**REQUEST**

Current Zoning: N1-A (Neighborhood 1-A)  
Proposed Zoning: NS (neighborhood services)

Approximately 0.99 acres located at the southeastern corner of the intersection of Steele Creek Road and Rigsby Road.

The petition proposes to allow the development of a 4,000 square foot commercial building with accessory drive-through for all uses permitted in the NS zoning district.

RZ1.0

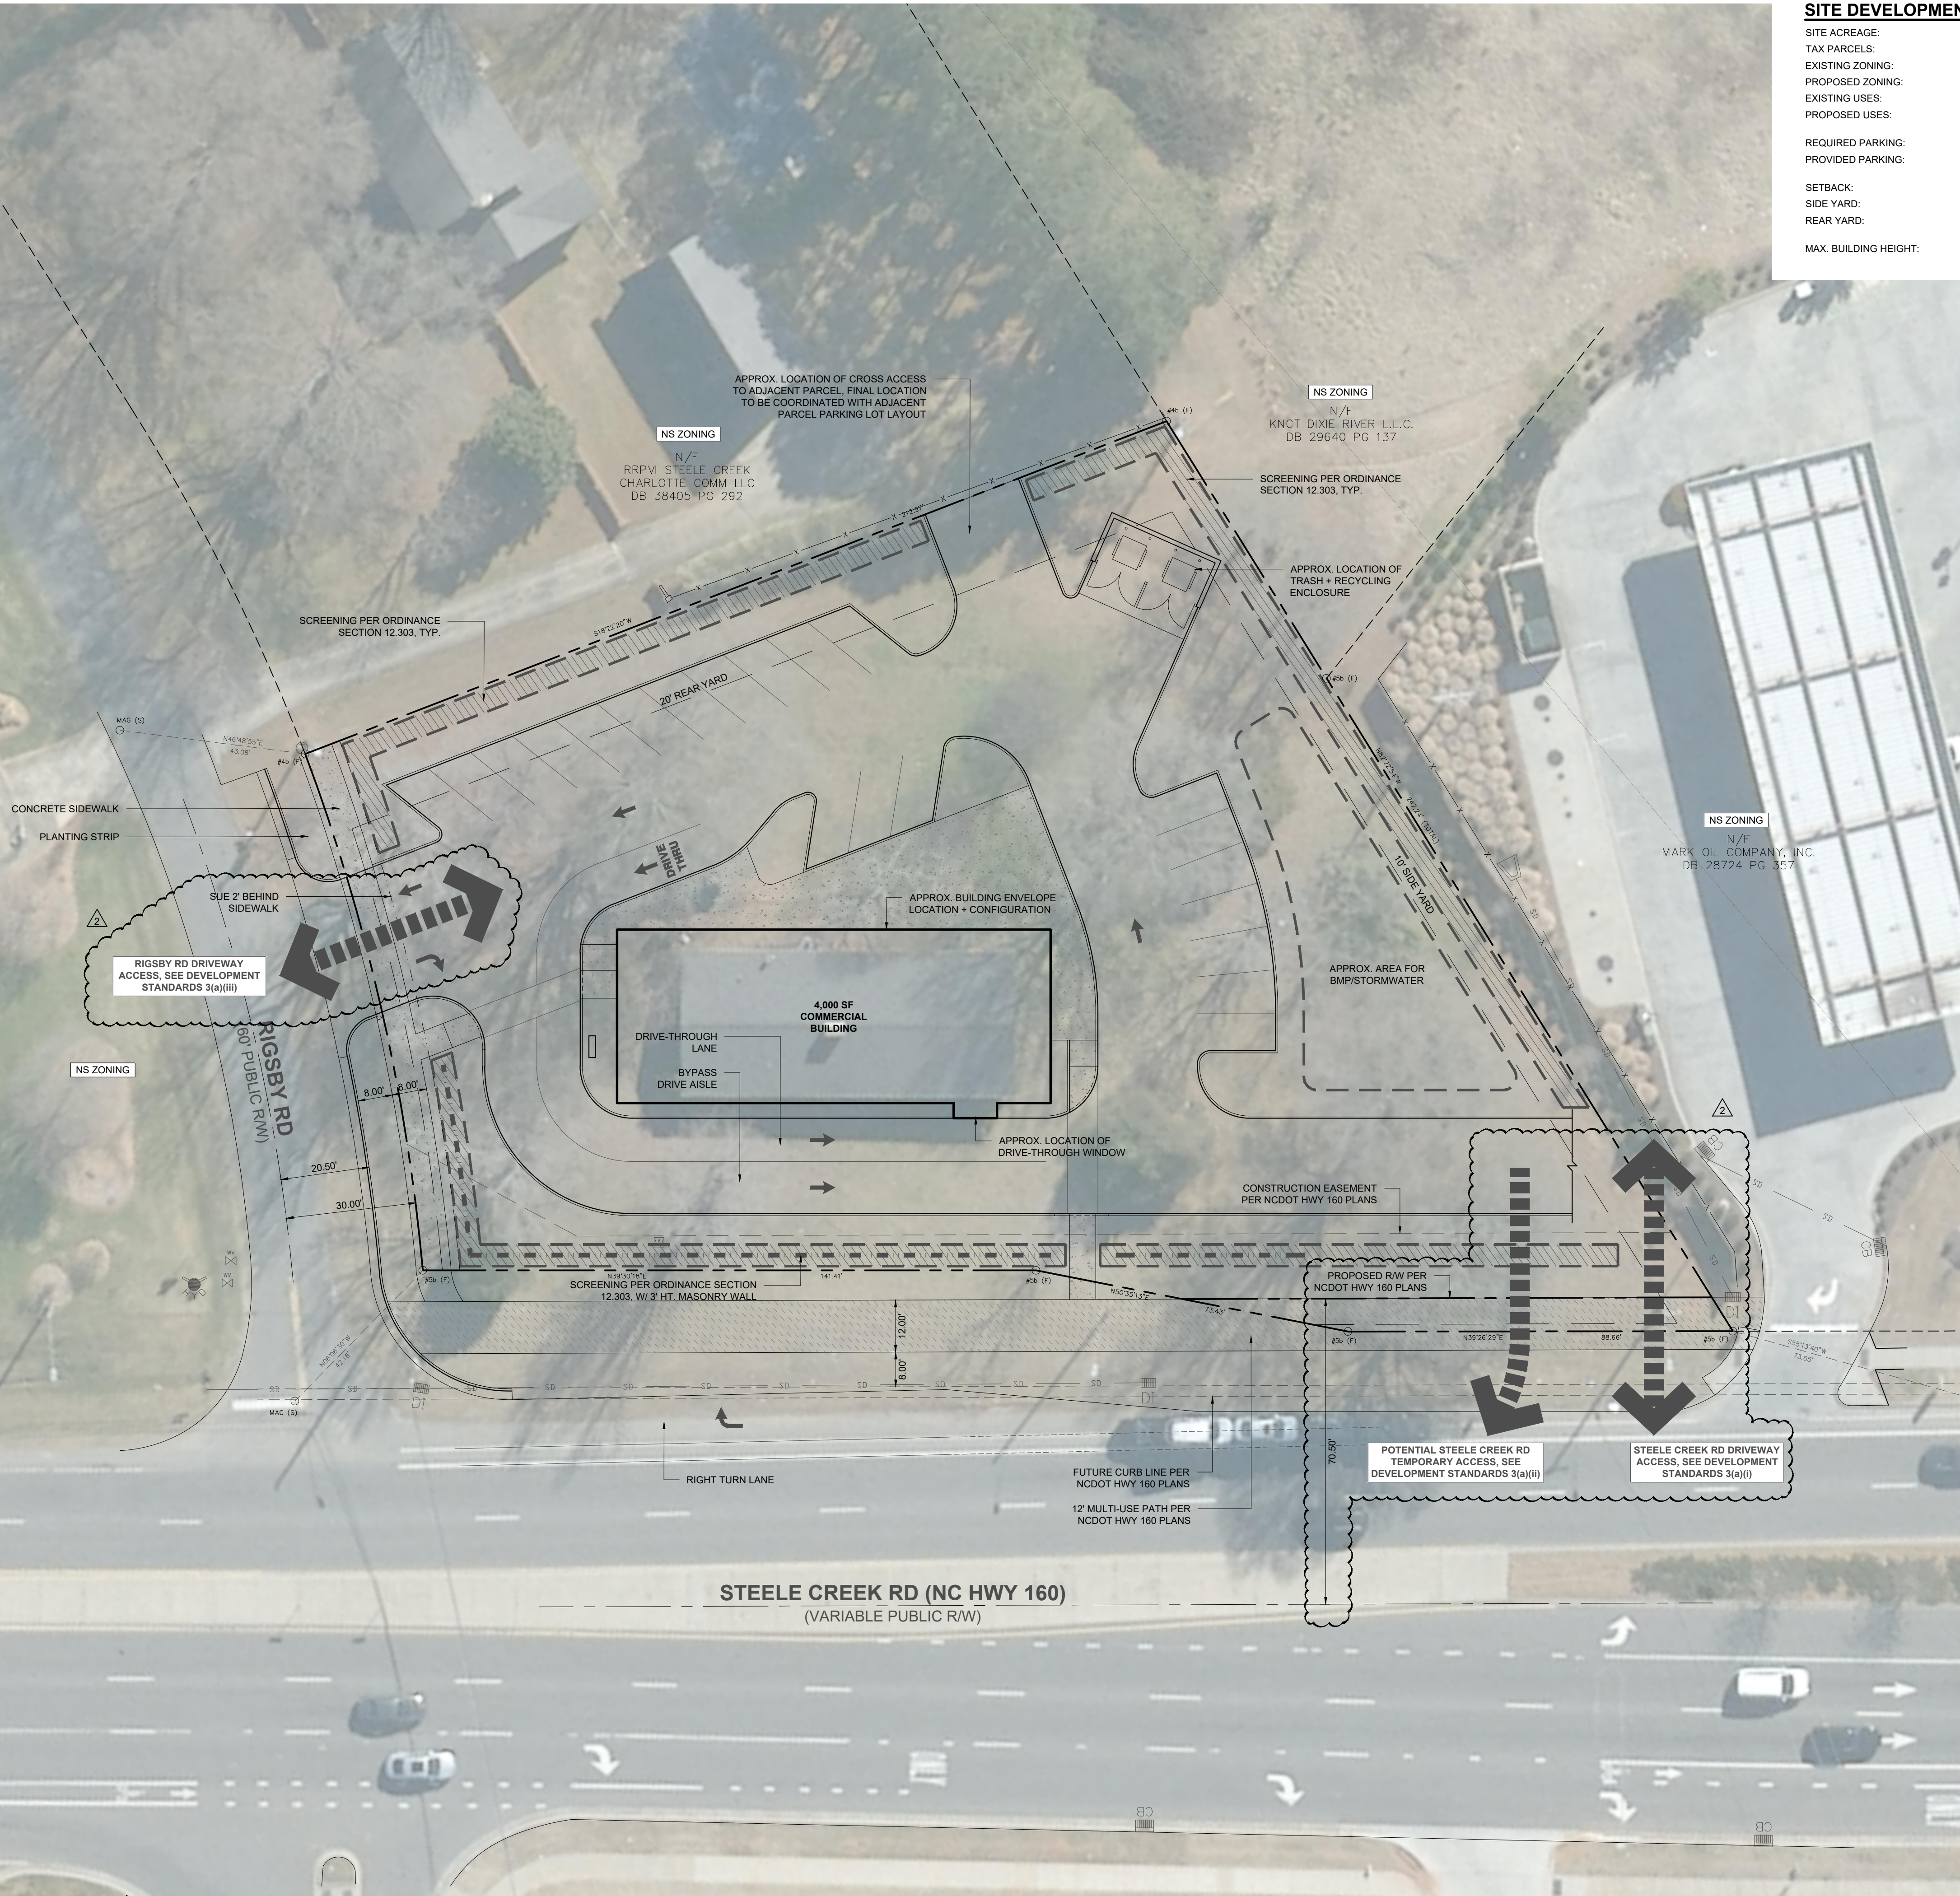
Site plan and conditional note revisions are needed and the outstanding items including, but not limited to labeling and dimension the right-of-way on Steele Creek Road, clarifying an unlabeled dimension on the site plan, and committing to providing an access easement with the adjacent parcel to provide cross-access. Further details are listed below.

- ~~1. Label and dimension the rights-of-way from centerline of Steele Creek Road and Rigsby Road.~~ **ADDRESSED**
- ~~2. Place a sidewalk utility easement 2' behind the sidewalk along Rigsby Road.~~ **ADDRESSED**
- ~~3. Revise the conditional notes by committing to provide an access easement, during permitting, with PID 20109114 to allow cross access as generally shown on the site plan.~~ **ADDRESSED**
- ~~4. Revise the site plan by clarifying the 6 foot dimension on the site's frontage of Steele Creek Road.~~ **ADDRESSED**
